CITY OF PORTLAND

March 31, 2004

RE: Coastal Equipment Corp. Expansion, 142 Presumpscot Street
ID #2003-0104, CBL #425-I-004

On March 31, 2004, the Portland Planning Authority approved the site plan for the expansion of the Coastal Equipment facility at 142 Presumpscot Street, as shown on the approved plan with the following conditions:

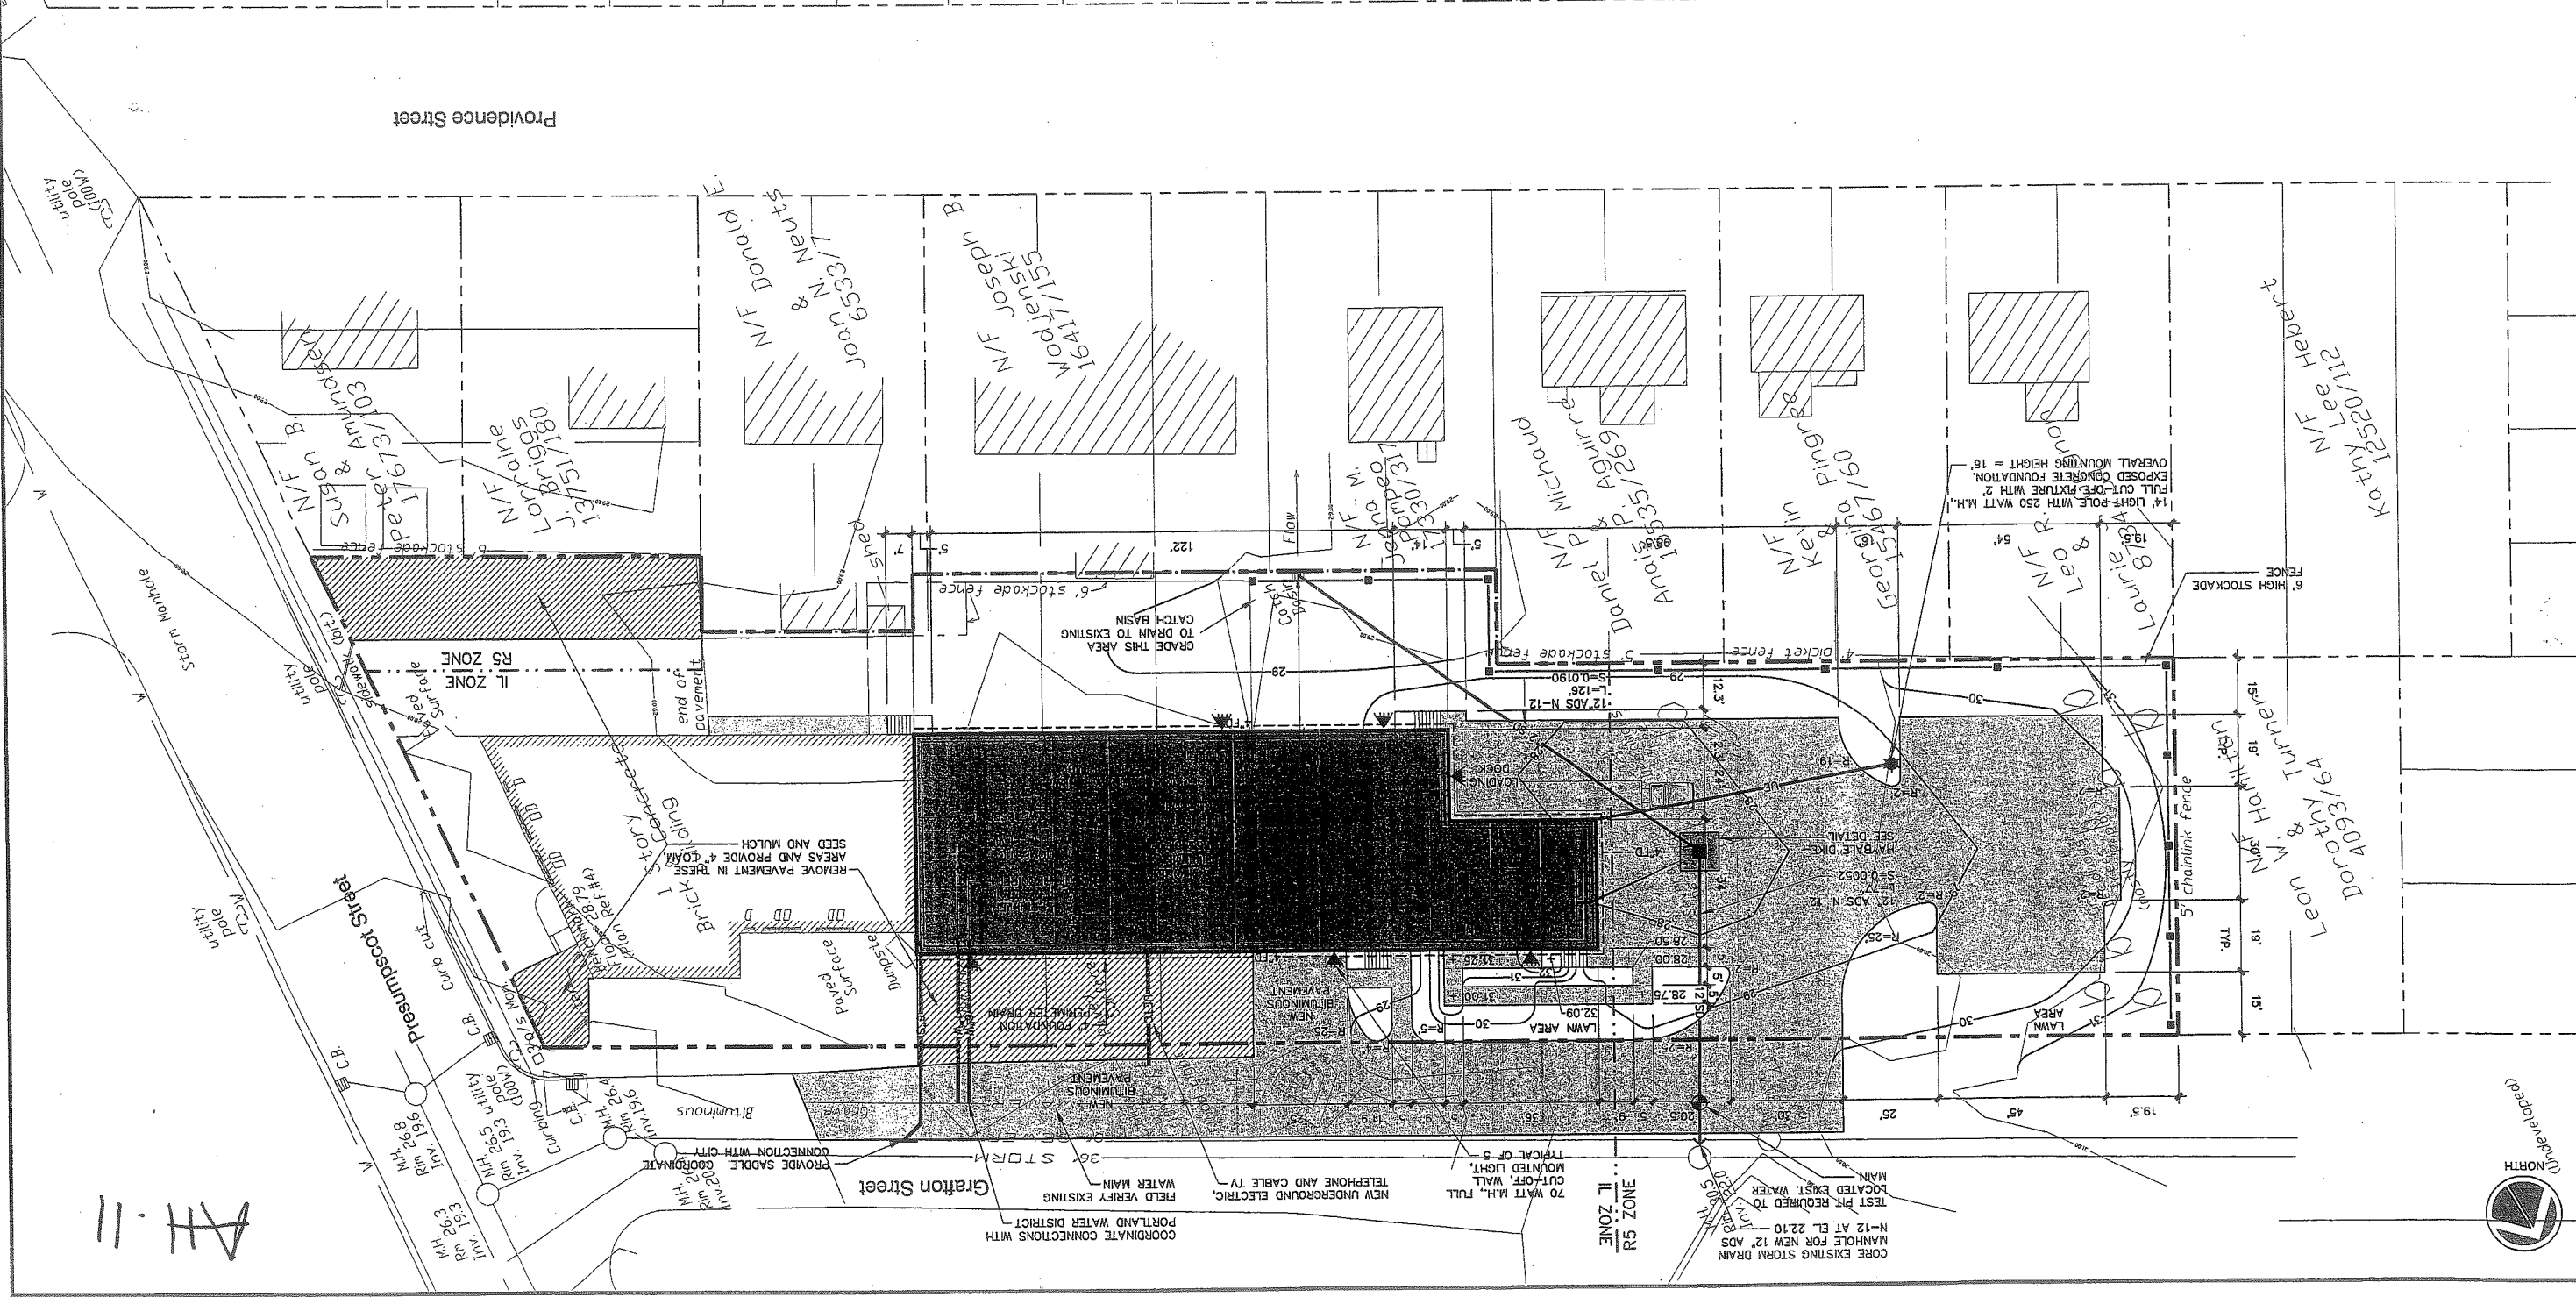
- i. The depths of the existing 8-inch sanitary and 36-inch storm sewer lines will be coordinated with the proposed utility companies to provide adequate ground cover.
- ii. Prior to issuance of the building permit, a geotechnical report will be required for the soil loading. The site is sitting on soft saturated clay and could be subject to settlement or frost action. A note shall be added identifying this condition.
- iii. A revised lighting plan will need to be submitted that meets our lighting standards.
